WEST SUSSEX COUNTY COUNCIL CONSULTATION

TO:	Arun District Council FAO: Richard Castro-Parker
FROM:	Stephen Gee WSCC - Highways Authority
DATE:	1 September 2019
LOCATION:	Land at Electricity Sub Station Ford Road Arundel BN18 9DX
SUBJECT:	AB/88/19/PL 38 No residential apartments (9 No 1-bed units & 29 No. 2-bed units) along with access, off-street parking, amenity space & enhancements to the local footpath network.
DATE OF SITE VISIT:	n/a
RECOMMENDATION:	Objection / More Information
S106 CONTRIBUTION TOTAL:	TBC

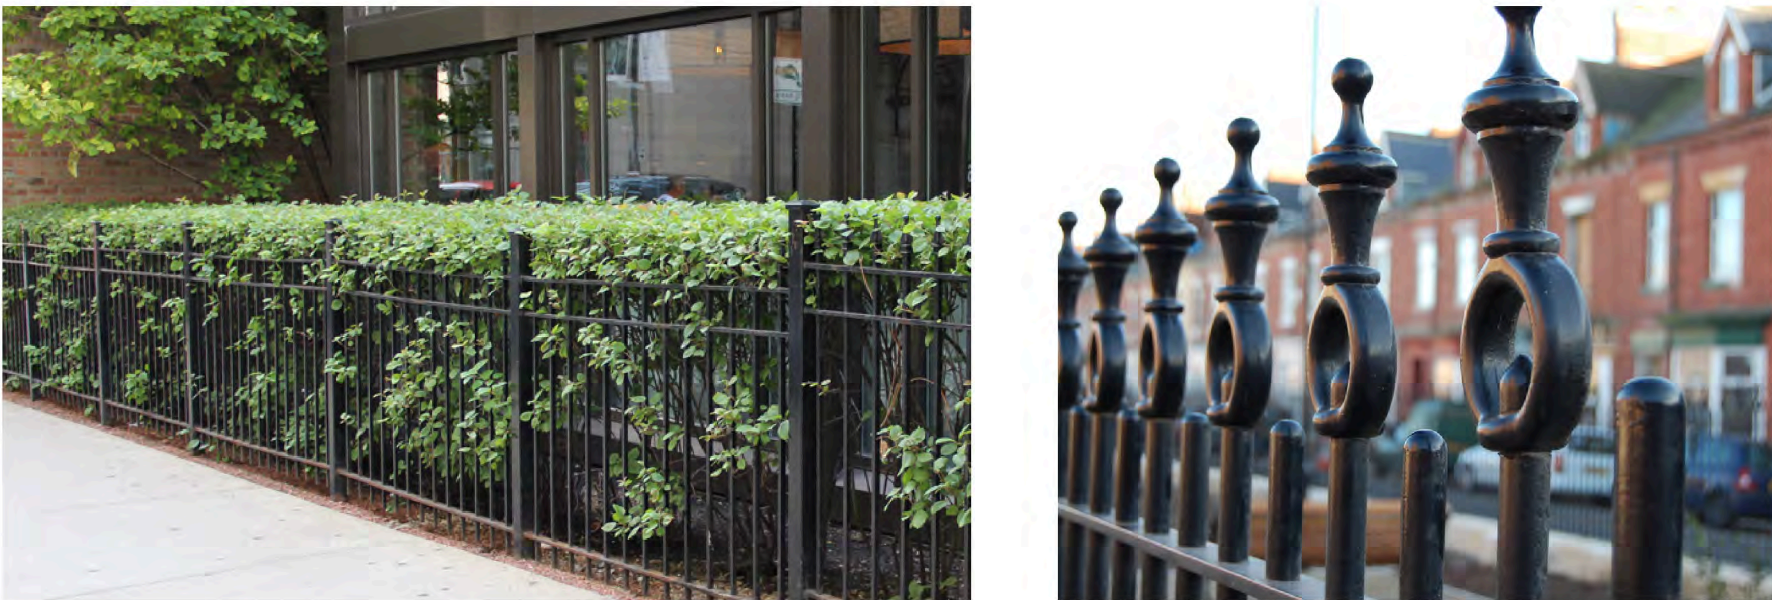
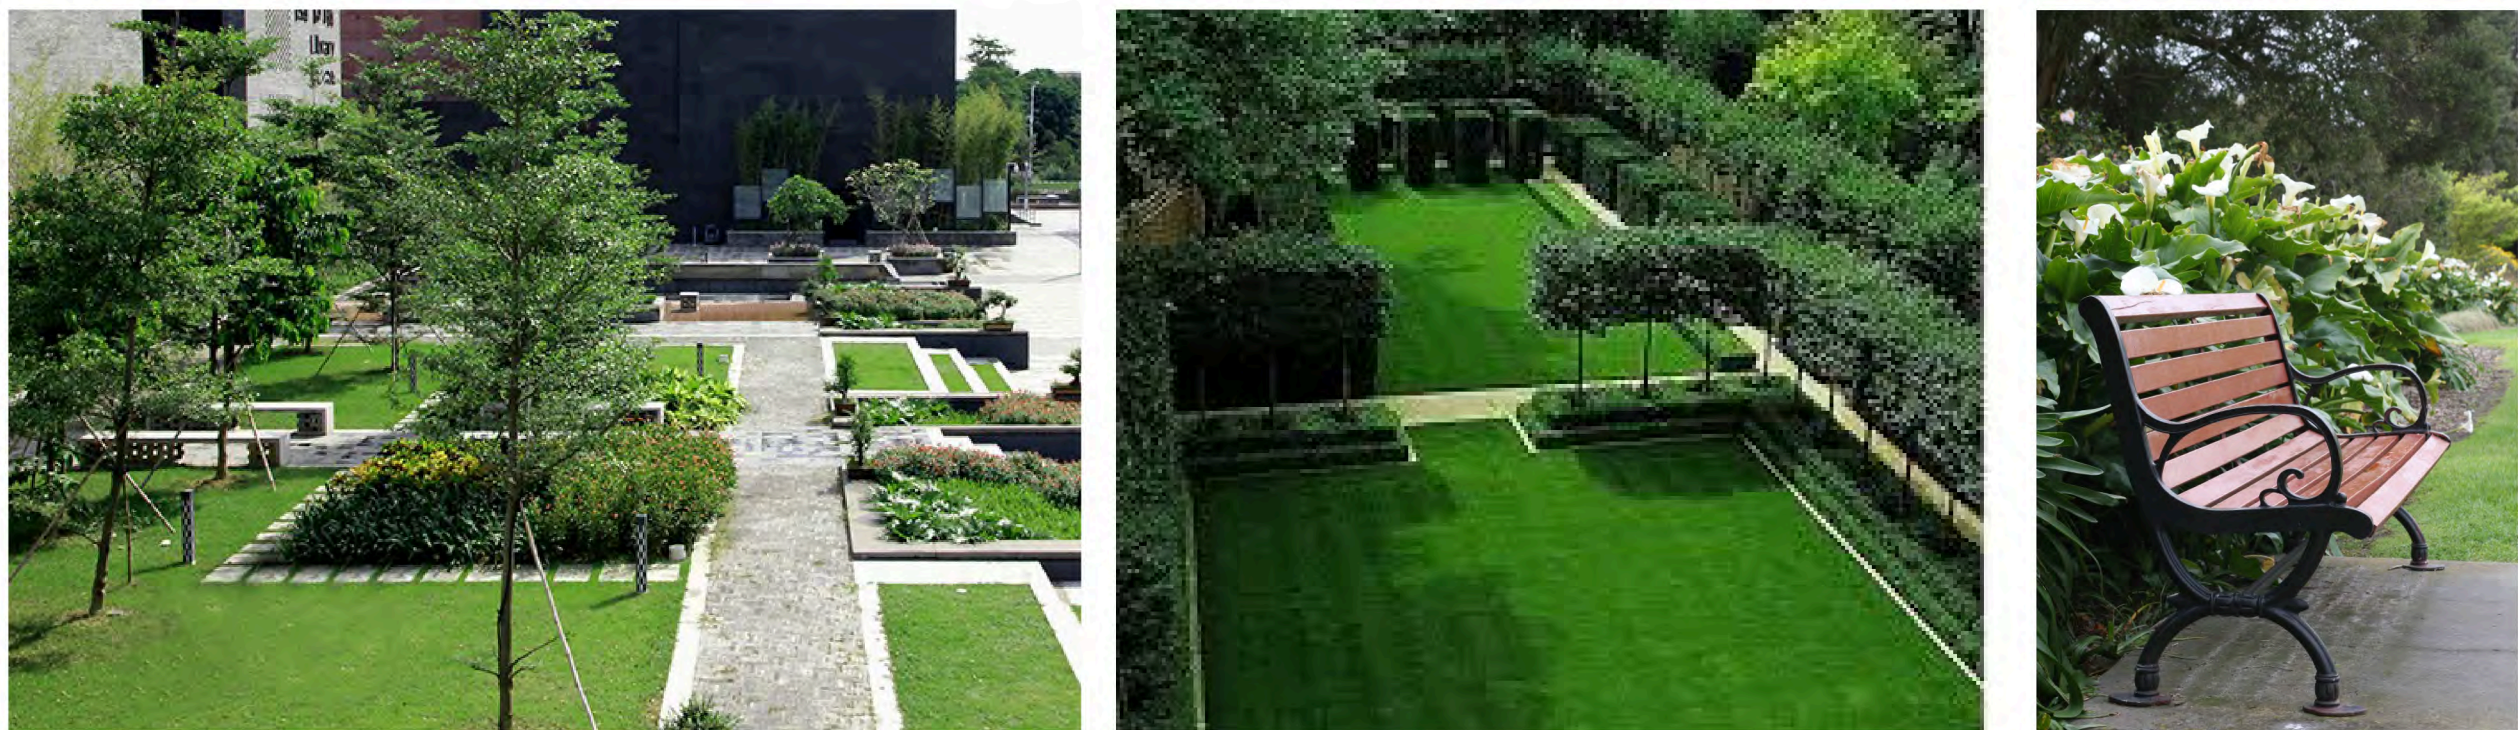
The planning statement details the scheme allows for a widening of the footway along the site frontage. Information should be provided on the additional width to be provided as part of the application as the land within the red line boundary to the Ford Road frontage is shown as amenity grass within the landscape plan submitted.
